Approval of details reserved by condition imposed under ref Y/82/20/RES relating to Condition Nos 5 - non-dig surfacing method and 8 - electric vehicle charging strategy.

Land to the south of Ford Lane and East of North End Road Yapton BN18 0DS

The information submitted regarding Condition 8 imposed on the reserved matters approval Y/82/20/RES: relating to an Electric Vehicle Charging Strategy is refused and the condition is hereby not discharged.

Title:
CAR CHARGING POINTS PLAN

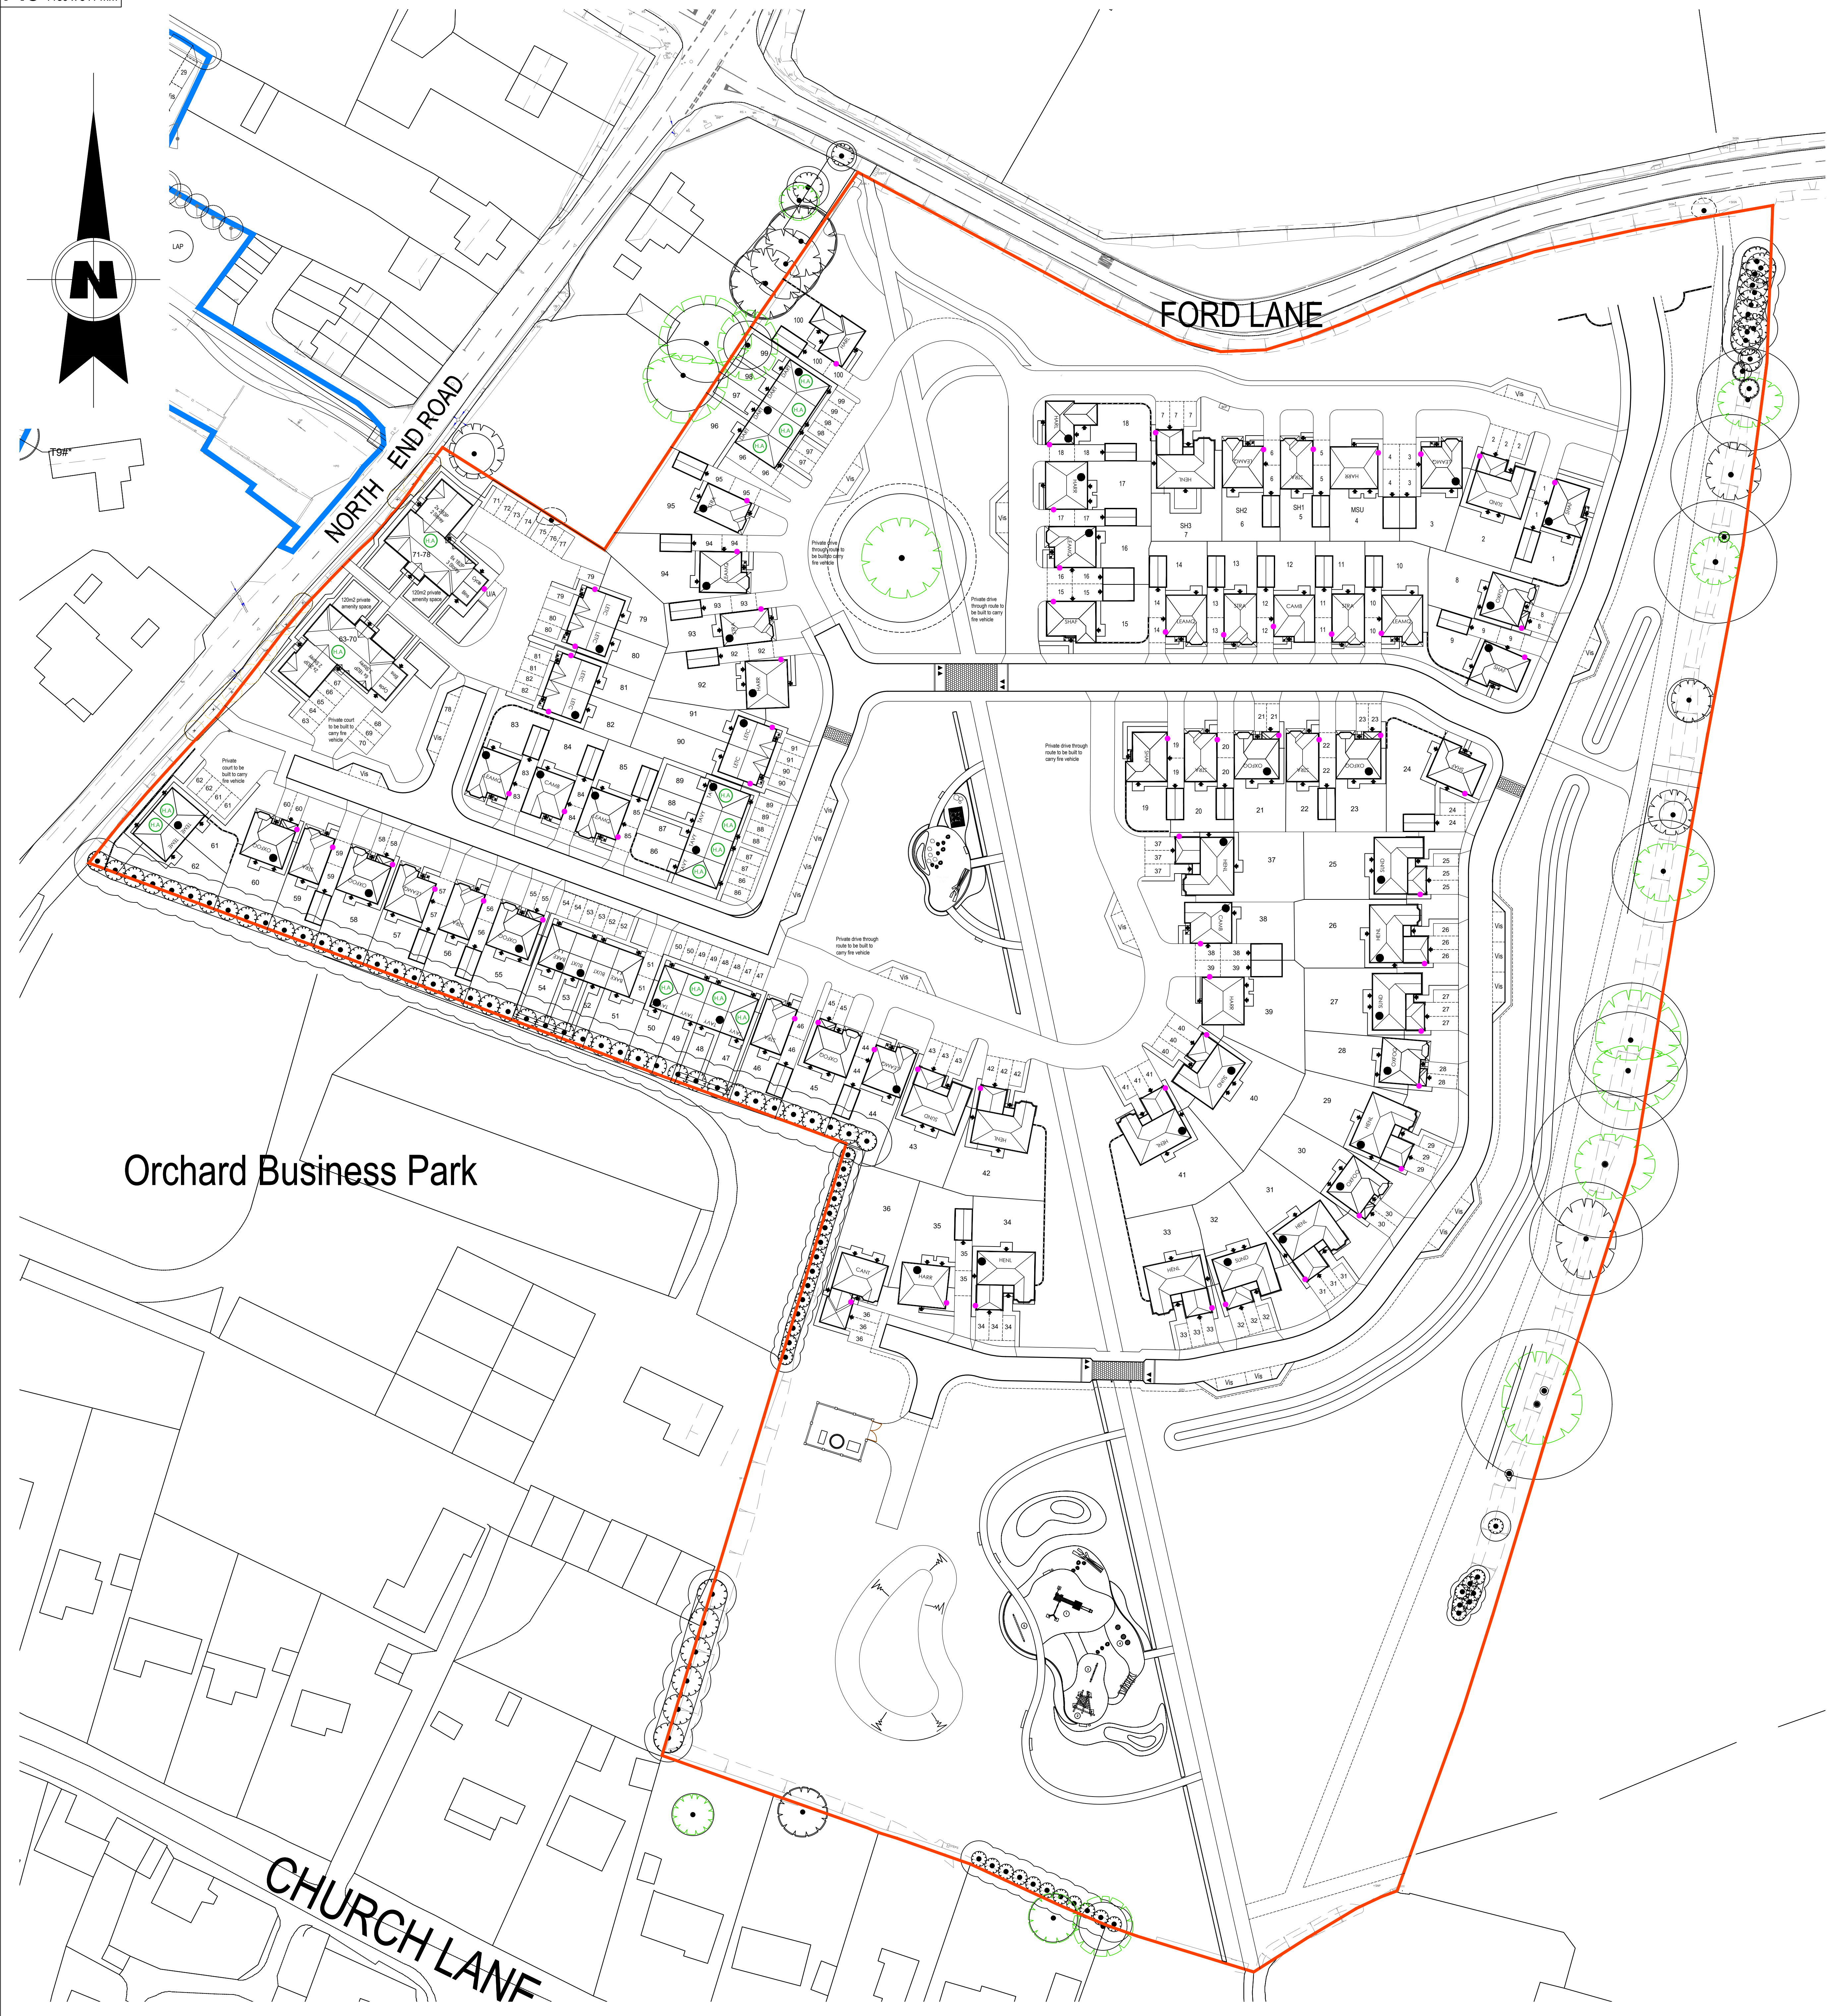
There are 15 flats served by 1 electric vehicle (ELV) charging point. The requirement for 'all other developments' in paragraph 2.8 and in Table 2.2 of the ADC Parking Standards SPD, January 2020

which includes flats is 20%, or 3 ELV charging points. ELV charging points should be provided for Plots 47-54, Plots 61-62, and Plots 86-91 and Plots 97-99. All of the spaces are clearly associated with these units and should all have ELV charging points; they are private driveways and are directly related to the units they serve.
